Consultation Response from KC Highways Development Management		
2026/90620 Central Warehouse, Bradford Road, Batley, WF17 5LW		
Demolition of existing building and erection of food/drink building with drive thru lane (Class E)		
Date Responded: 25/08/26	Responding Officer: M Zenner	Responding Ref: 13-10SE/9

RECOMMENDATION: HDM considers that whilst additional information has been provided it is not sufficient to overcome highways concerns in relation to the proposals and to comply with NPPF TR6.

Swept Path Analysis - Large Car - Scale 1/200

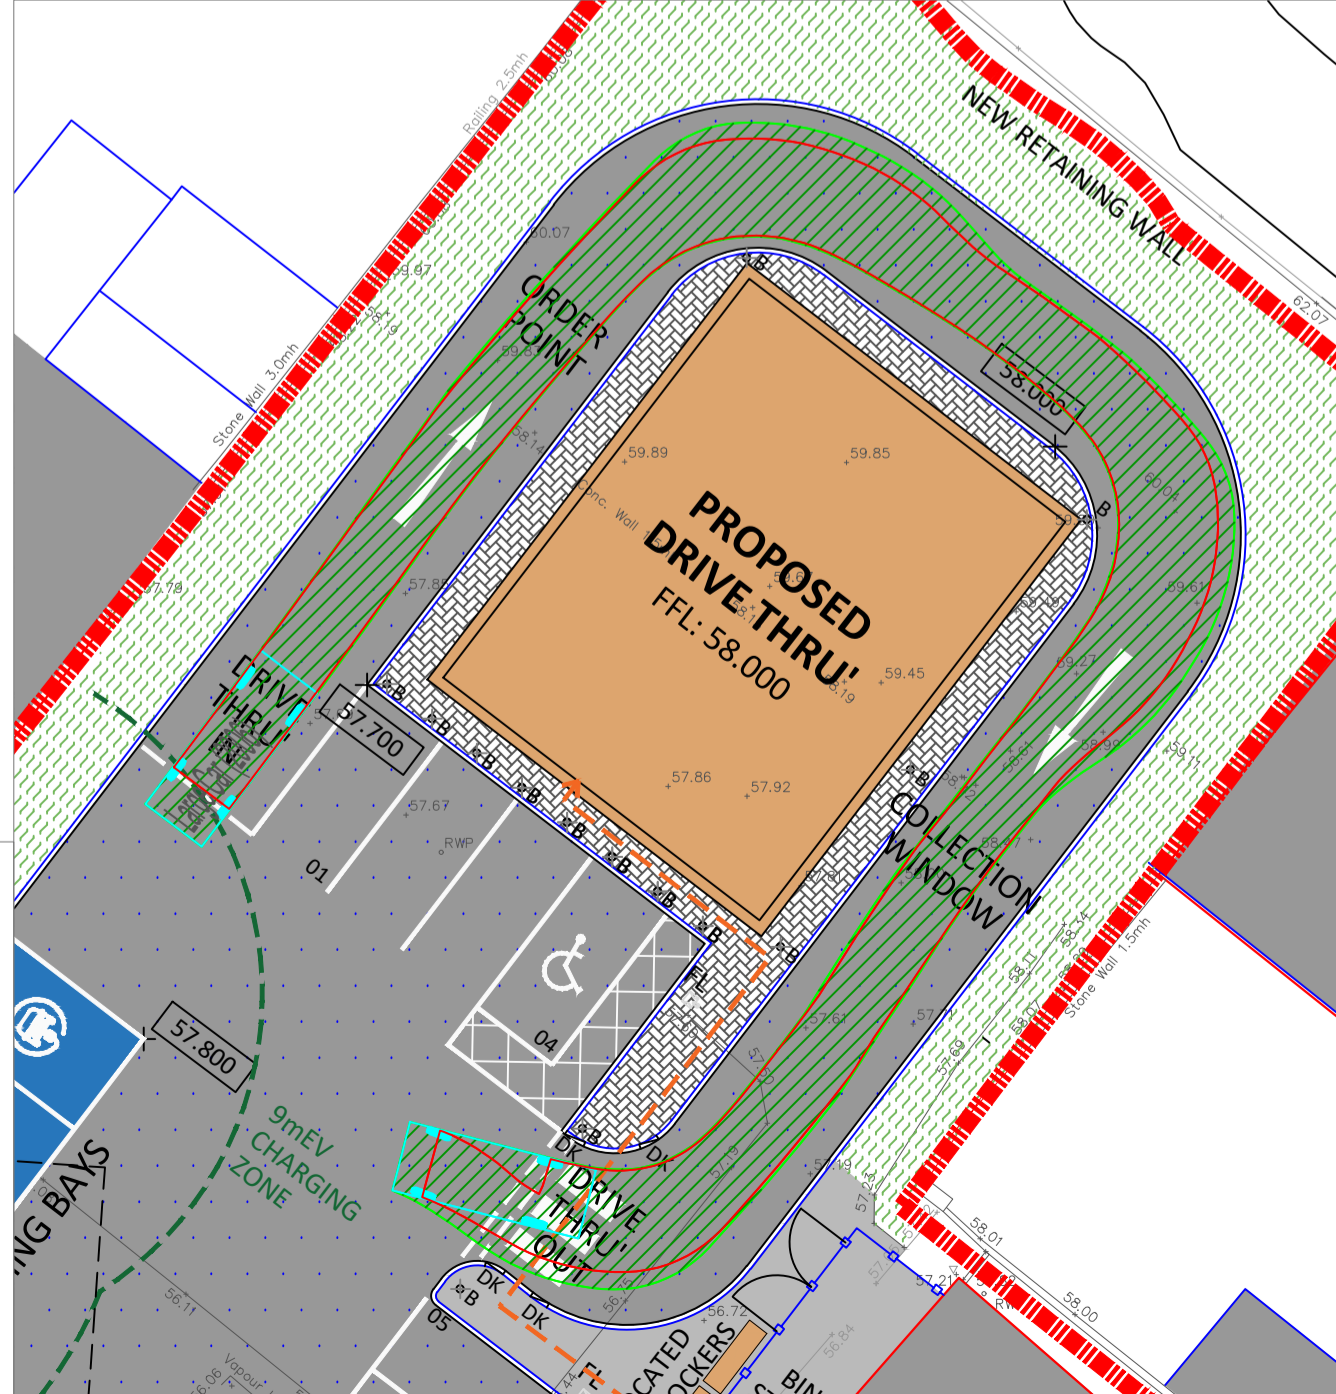
HDM previously requested swept paths to be provided for the site. Dynamic Transport Planning have provided swept paths for the largest vehicles they deem will service or access the facilities. They have detailed a large car accessing / egressing part of the drive thru lane, but do not show vehicles negotiating the tight alignment on the approach and exit from the drive thru lane; which is required. Furthermore, large vans are likely to use the drive thru and therefore larger vehicles should have been shown accessing the full route into and out of the site and the drive thru lane also.

The swept paths provided also show the oil tanker servicing the site using the relocated offsets fills which have been relocated to in-between the pumps. The vehicles accessing via the western access on Bradford Road appear to track exceptionally close to the proposed kerblines and may cause damage on part of the public highway. 0.5m clearance to kerbing or vertical obstructions on each side of the swept path should be provided. Designs should therefore, where possible, aim to cater for vehicles larger than the above minimum standards.

A swept path has been provided for a 10m rigid which appears to service the drive thru unit, but it accesses by driving towards the pumps and reversing back towards the accessible bay, which could cause conflicts within the site as this occurs in close proximity to the pedestrian path indicated within the site, furthermore the vehicle would block egress from the drive thru lane and impede vehicles intending to access the drive thru lane, plus it may impede vehicles intending to exit parking spaces 1-7 plus several of the EV charging bays. To exit the site the vehicle would need to exit through the pumps and would require the central four pumps to be clear of vehicles to have adequate space to exit. HDM is concerned that this could cause queuing and obstruction within the site which could cause queuing back onto the public highway.

It is noted that an RSA brief has been submitted by Dynamic Transport Planning, however, at this stage HDM cannot support the arrangements due to the potential for queuing and obstruction at the access to the site and the issue with the oil tanker swept path detailed above.

HDM is concerned that this arrangement appears very tight for vehicles manoeuvring in and out of the site due to the presence of the EV charging spaces and proposed car parking spaces within the site, the swept path proposed only shows vehicles on the loop itself not accessing and egressing the drive thru lanes.

Proposed Highway Works - New Kerblines - Scale 1/100

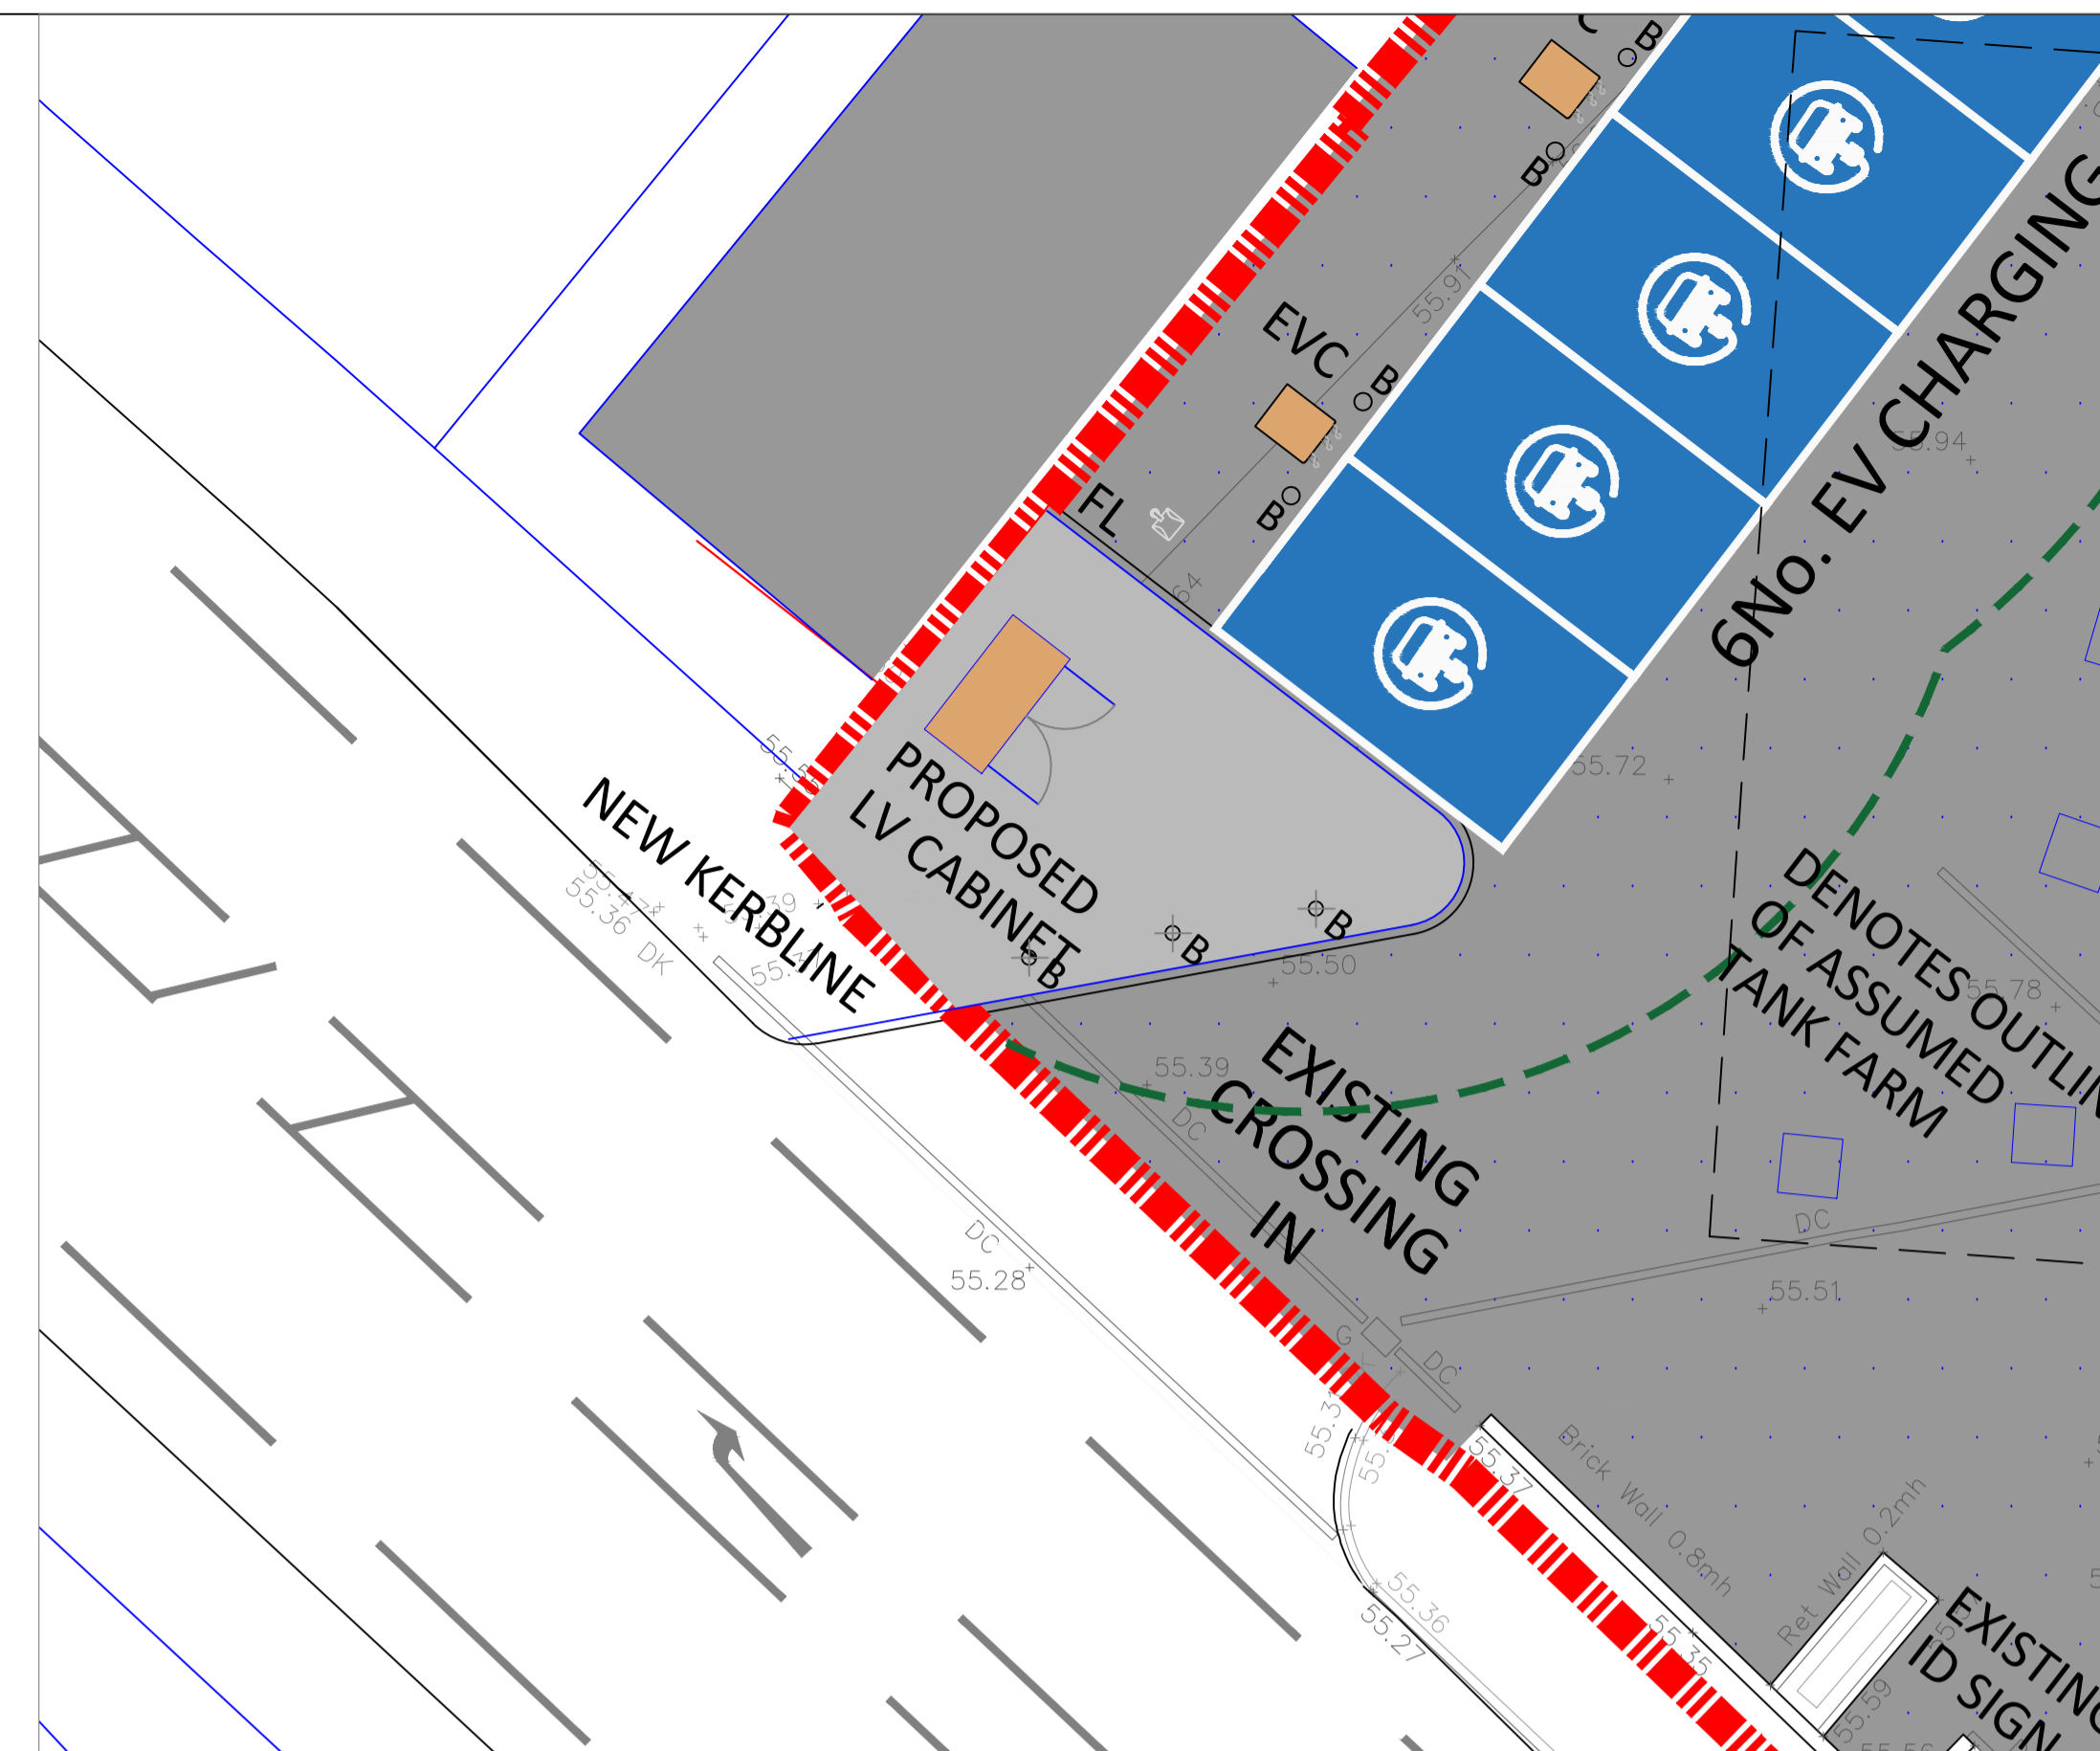
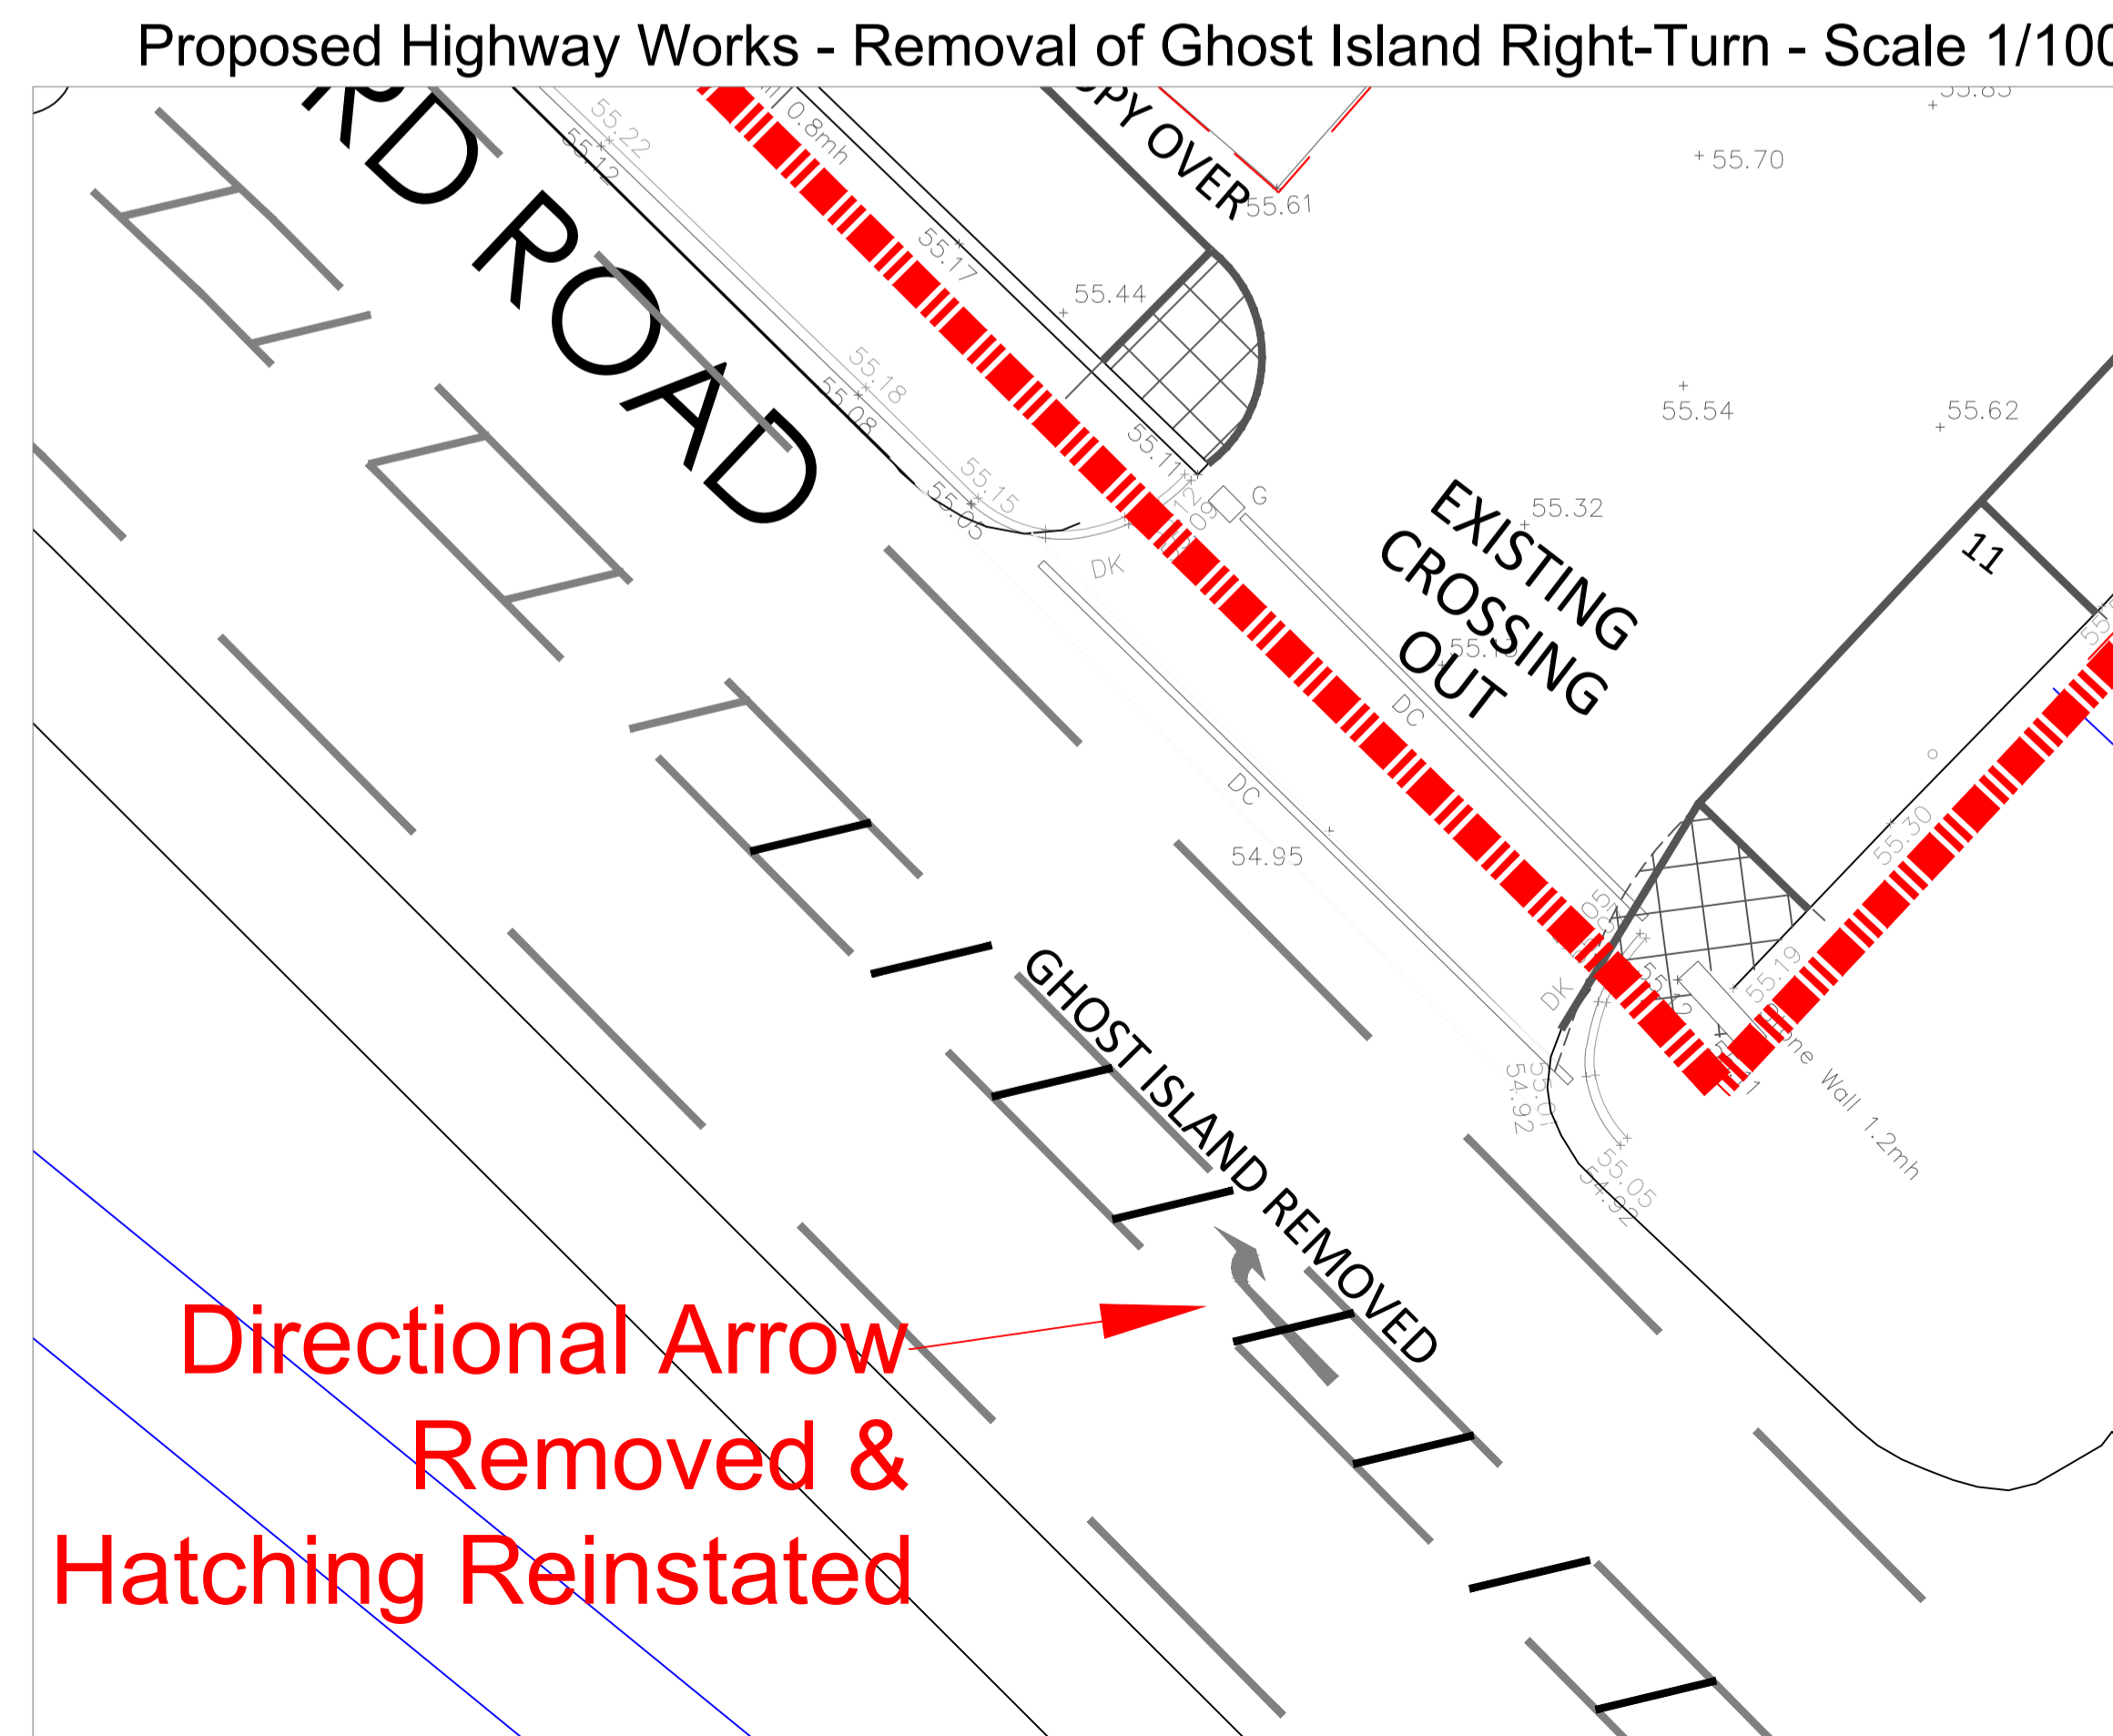
The proposed site layout plan appears to show no change to the southern 'out' access but shows a new kerbline to be constructed within the existing northerly 'in' access to allow for hardstanding to accommodate an LV cabinet and EV charging bays. Should this amendment be approved by the LPA, it

would require an amendment to the dropped kerb which would need to be delivered via a Section 278 agreement or another appropriate agreement that is agreed with the Highway Authority.
